# CITY OF ALBUQUERQUE

**RE: 5210 Central Ave SE  
PERMANENT C.O. – Accepted  
Engineer’s Certification Date: 02/09/2026  
Engineer’s Stamp Date: 10/11/2022  
Hydrology File: K17D080  
Case # HYDR-2026-00058**

RONALD R. BOHANNAN P.E. #7868	CENTRAL TAKE 5 ALBUQUERQUE, NM		DRAWN BY BF
	GRADING & DRAINAGE PLAN		DATE 08/24/2022
	TERRA WEST, LLC 5571 MIDWAY PARK PLACE NE ALBUQUERQUE, NM 87109 (505) 858-3100 www.tierrawestllc.com		2022079_GRE
	SHEET # C4.2		JOB # 2022079

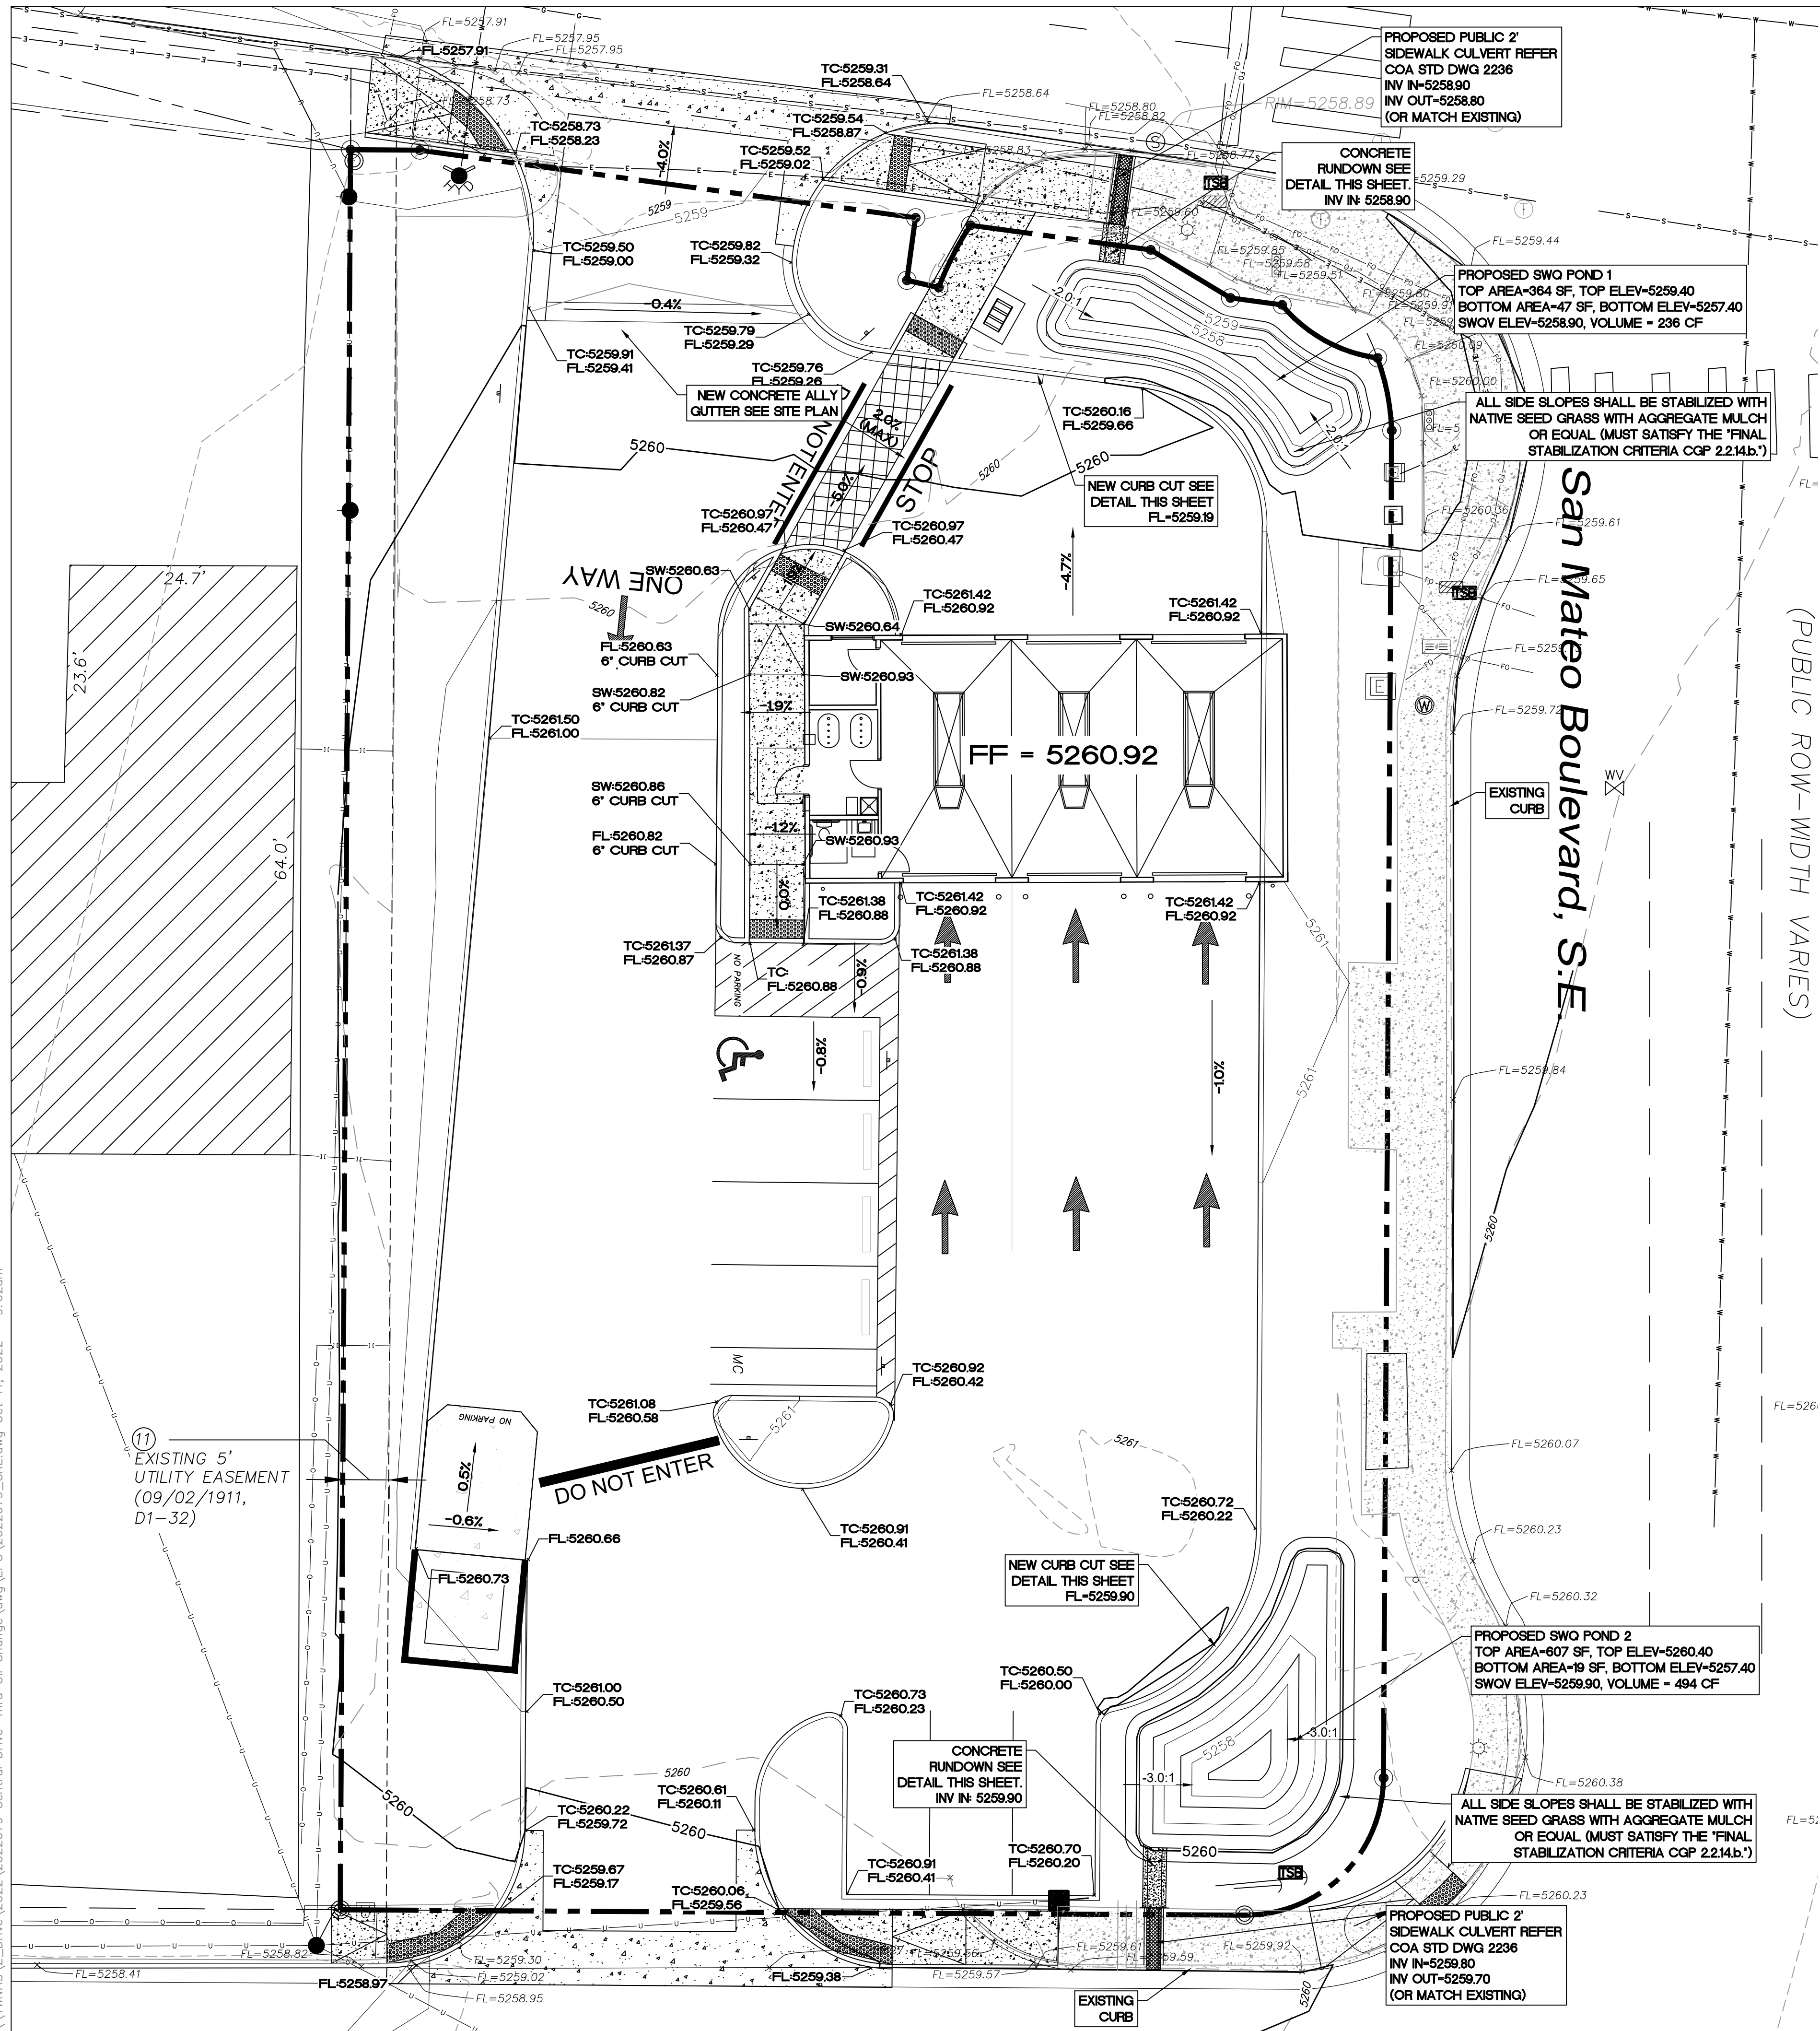
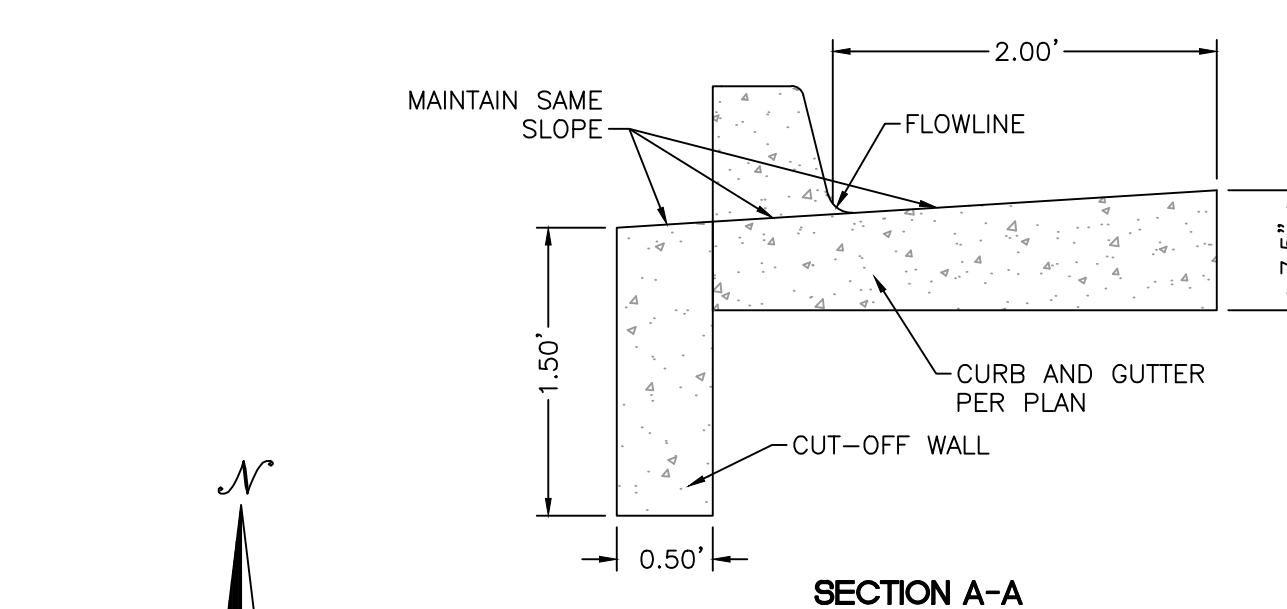
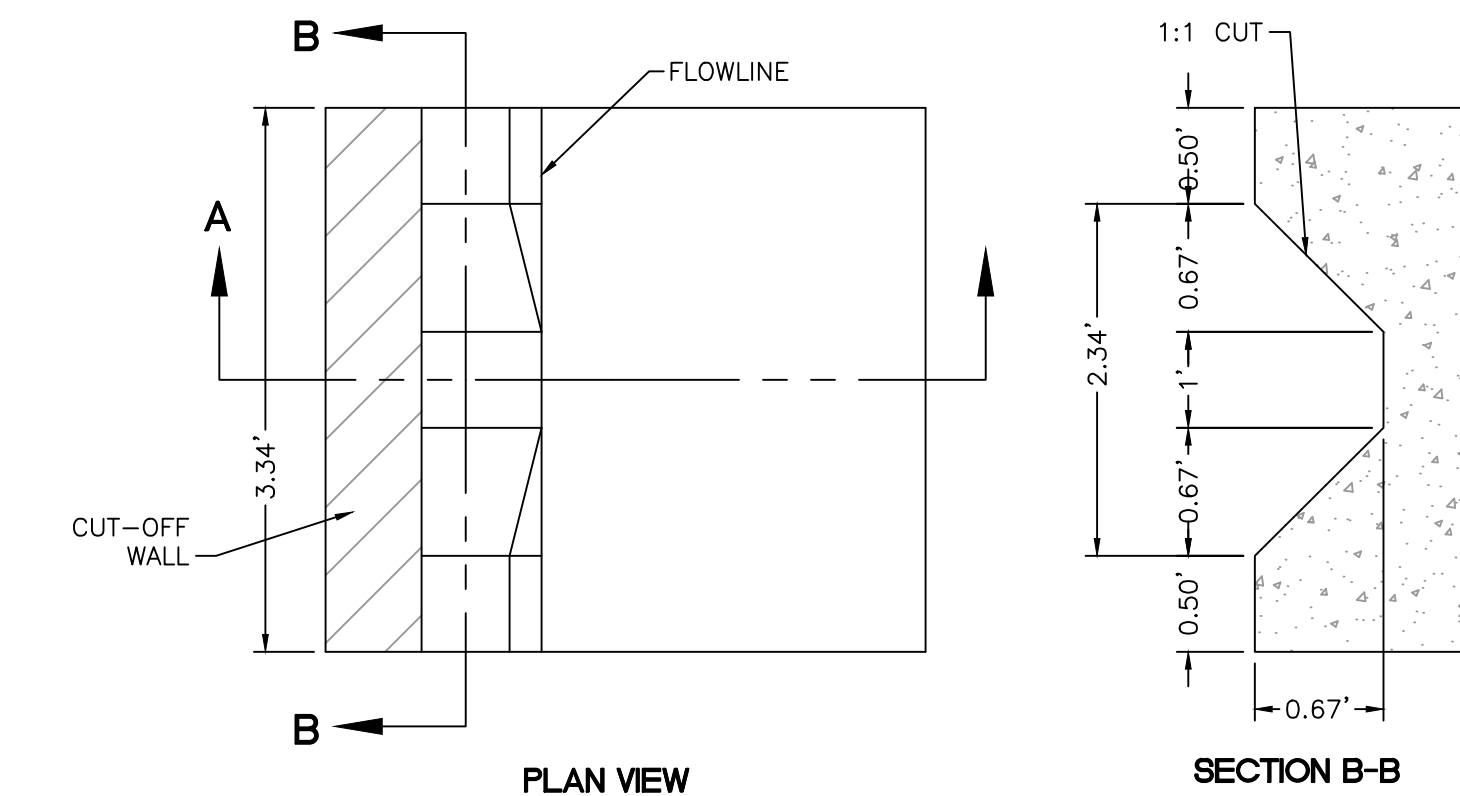
1. Provide the executed paper Drainage Covenant (latest revision) printed on one-side only with Exhibit A and a check for \$25.00 make out to “Bernalillo County” for the stormwater quality ponds per Article 6-15(C) of the DPM to Hydrology for review at Plaza del Sol. Additionally, please submit the Drainage Covenant to ABQ-Plan.
2. Curb cut to be added at Pond 1 per plans:
